WOODMOOR

Water & Sanitation District No. 1

November 22, 2017

RE: The Beach at Woodmoor PUD/Preliminary Plan (PUDSP-17-003) and The Beach at Woodmoor Final Plat (SF-17-015) - REVIEW 2

THE BEACH AT WOODMOOR FILING NO. 1

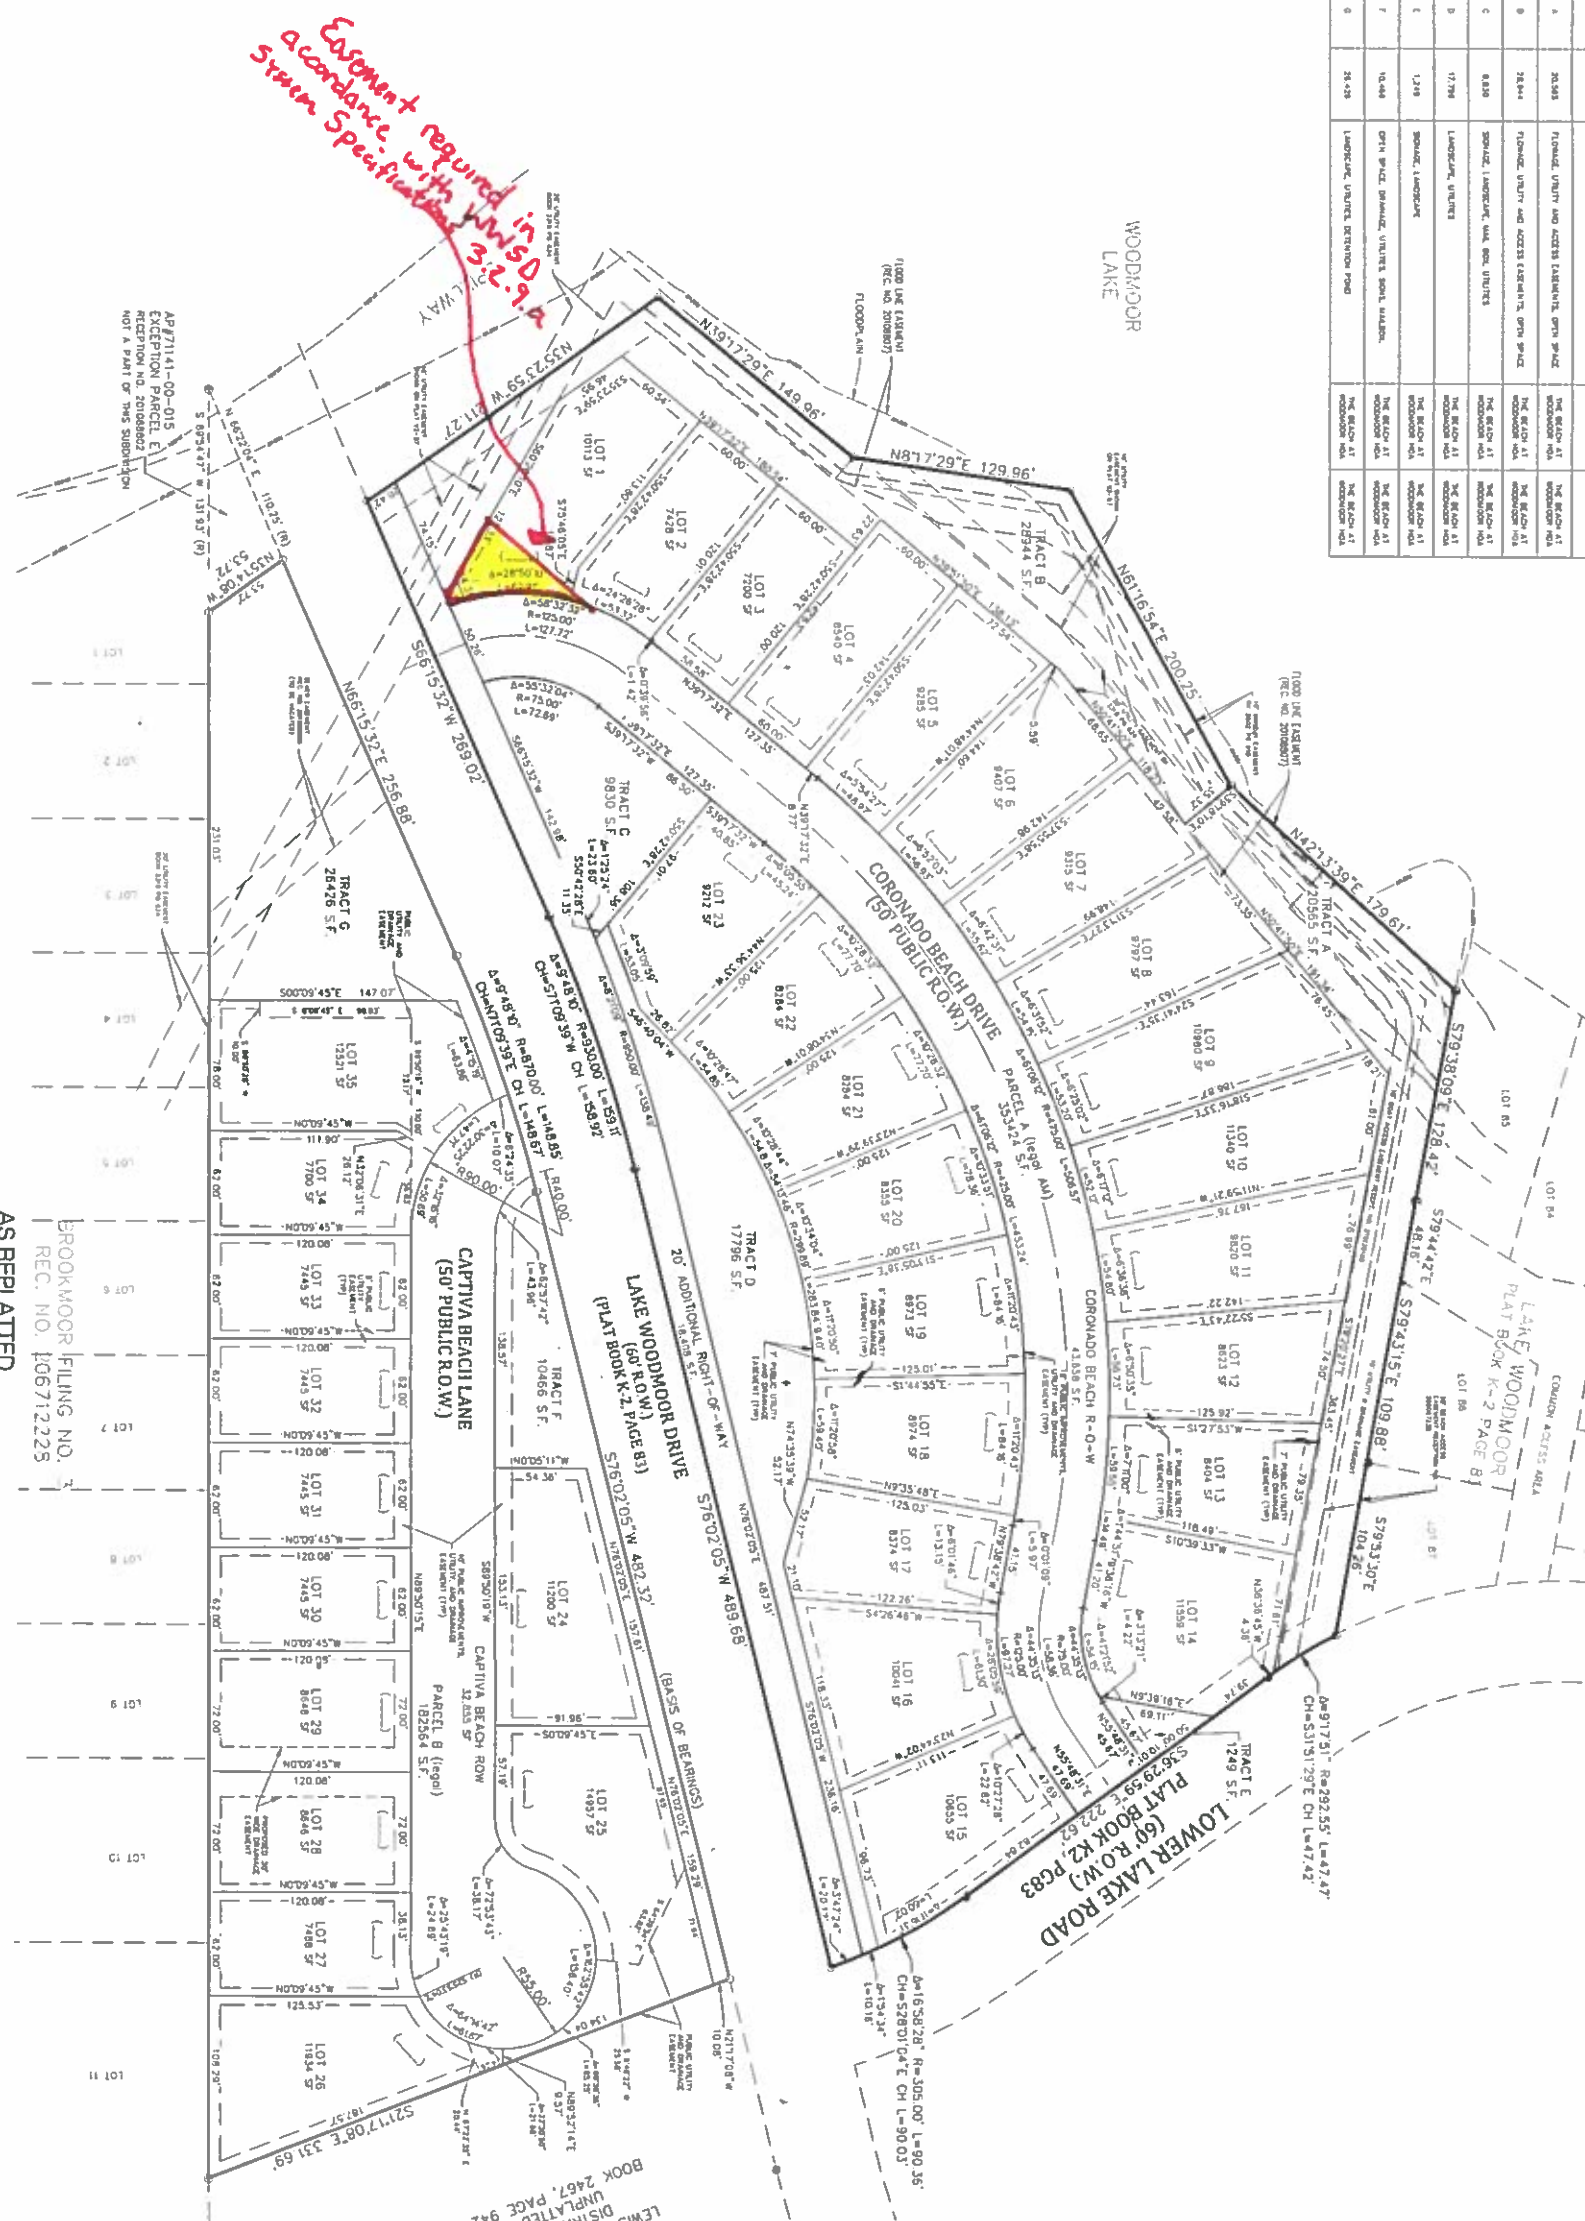
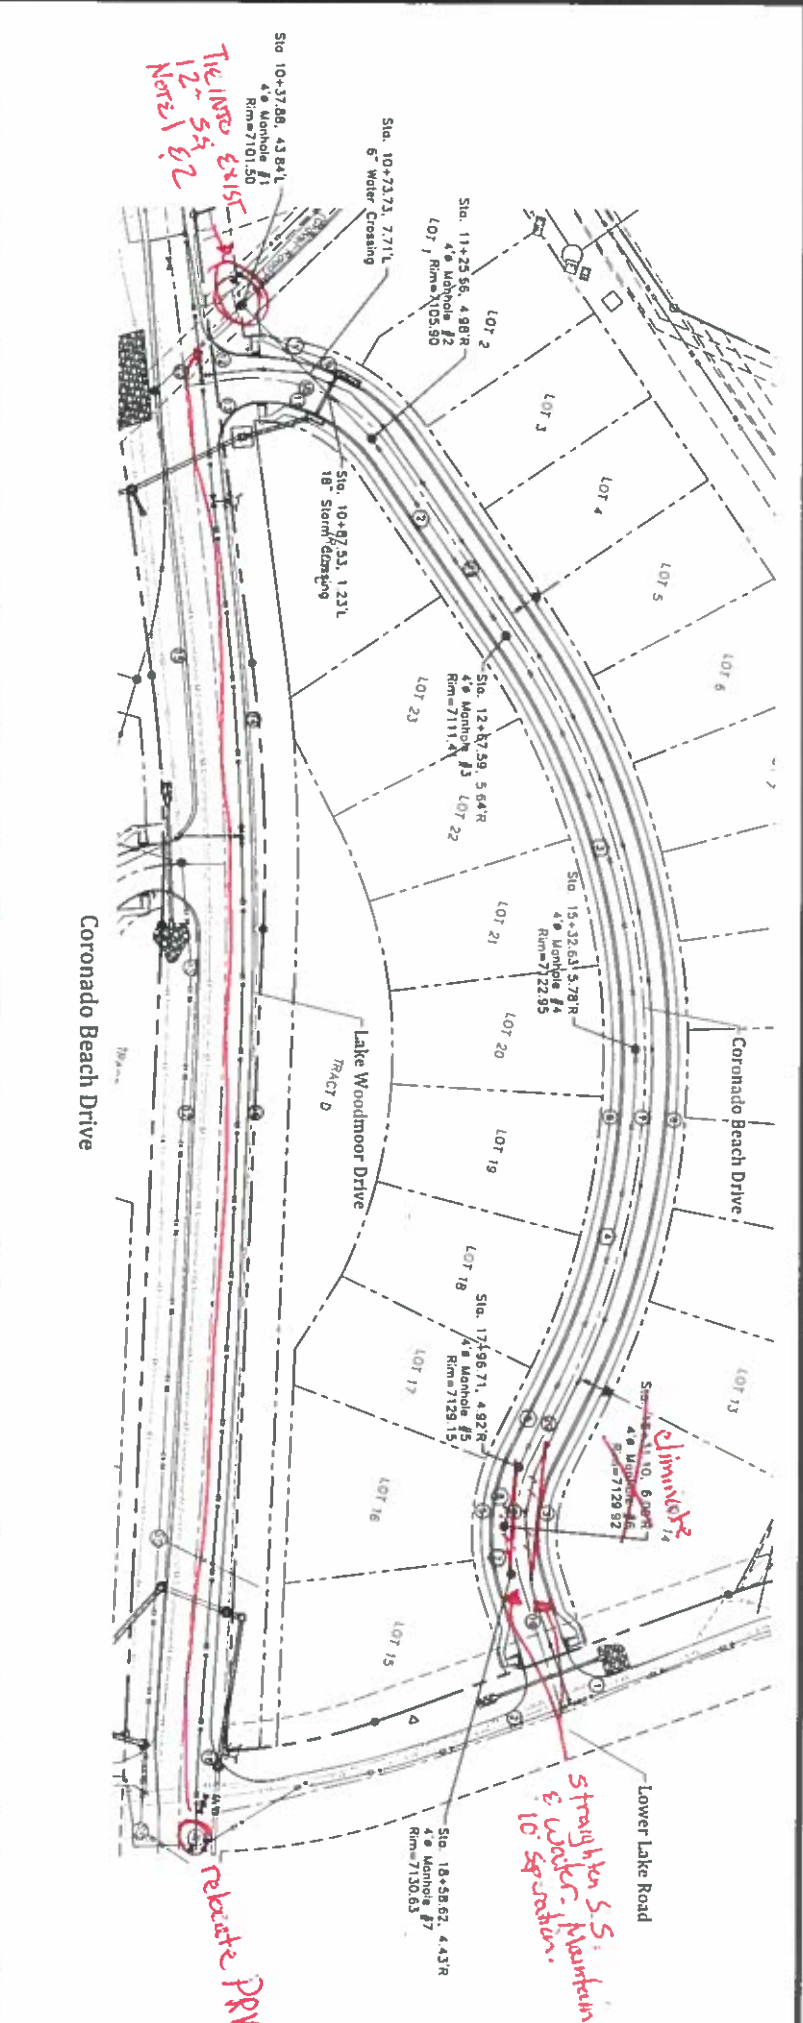
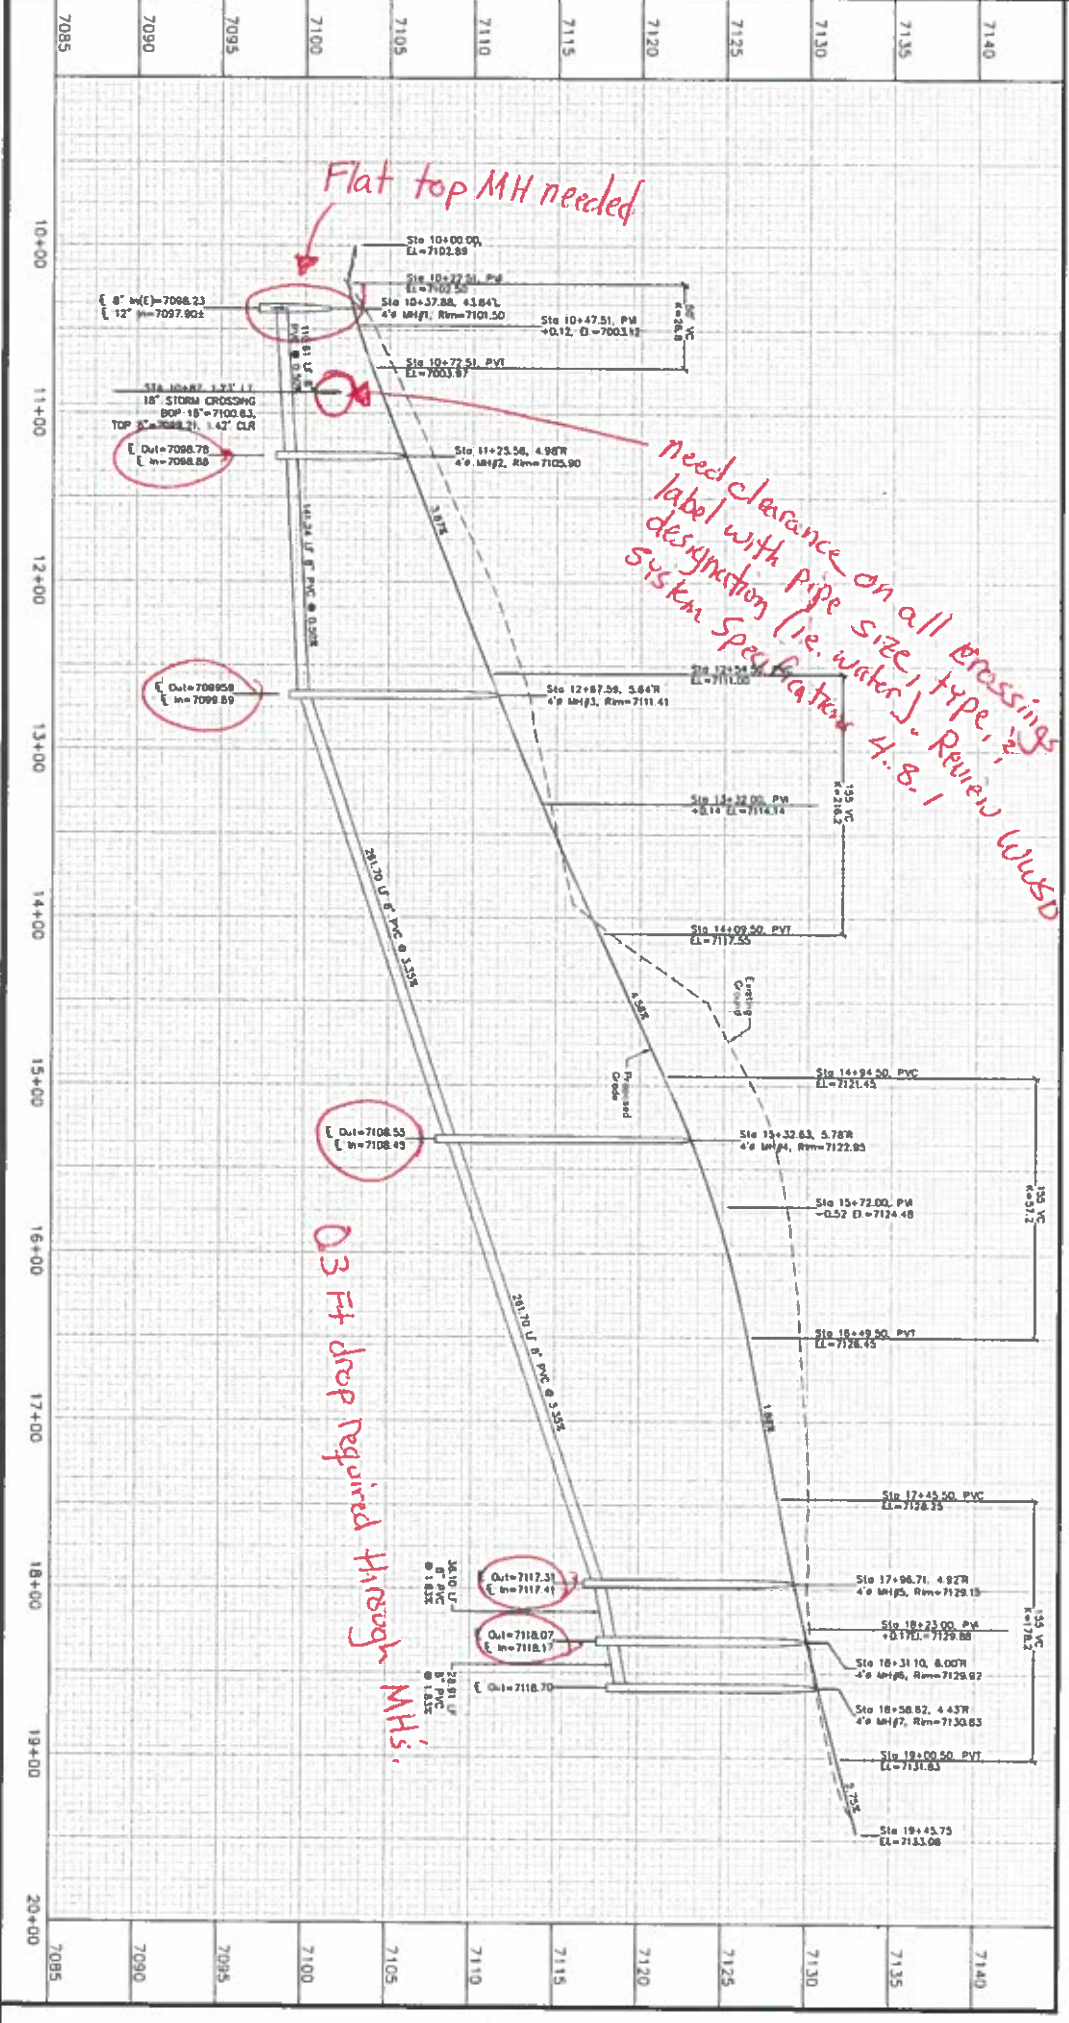
1. Per WWSD System Specifications 3.2.9.a, "All existing and future system improvements owned by the District will be contained within dedicated easements or public right-of-way. Easement widths for sewer pipe installations shall be a minimum width of thirty (30) feet or as determined by the District. All easements will be finalized by a separate easement agreement between the District and the

Developer/Owner or, if approved, by final plat. No separate easement agreements will be required provided all system improvements reside within public rights-of-way.”
The sanitary sewer line shown to cross Lot 1 will require, at a minimum, a platted public utility easement for it to reside within.

The Beach at Woodmoor Filing No. 1
 Coronado Beach Drive -- Plan and Profile
 Sanitary Sewer -- Plan and Profile
 El Paso County, Colorado

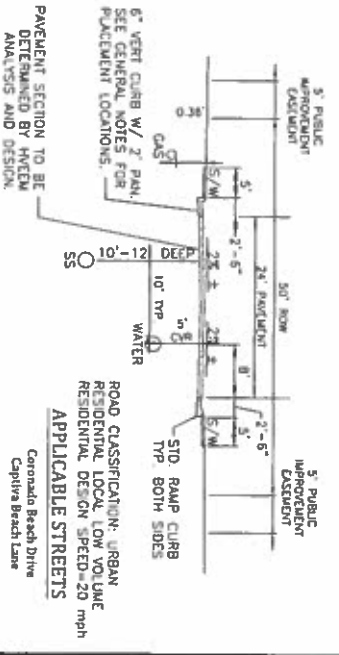
1. Per WWSD System Specifications 3.2.5.5, “The elevation drop through the trough of a manhole shall be 0.30 feet.” Elevation drops through manholes vary; revise to conform to System Specifications.
2. Per WWSD System Specifications 4.8.1, plans must show more details (ex. MH cut depth, etc.). Review District Plan and Profile requirements (Chapter 4) and revise The Beach package for compliance.
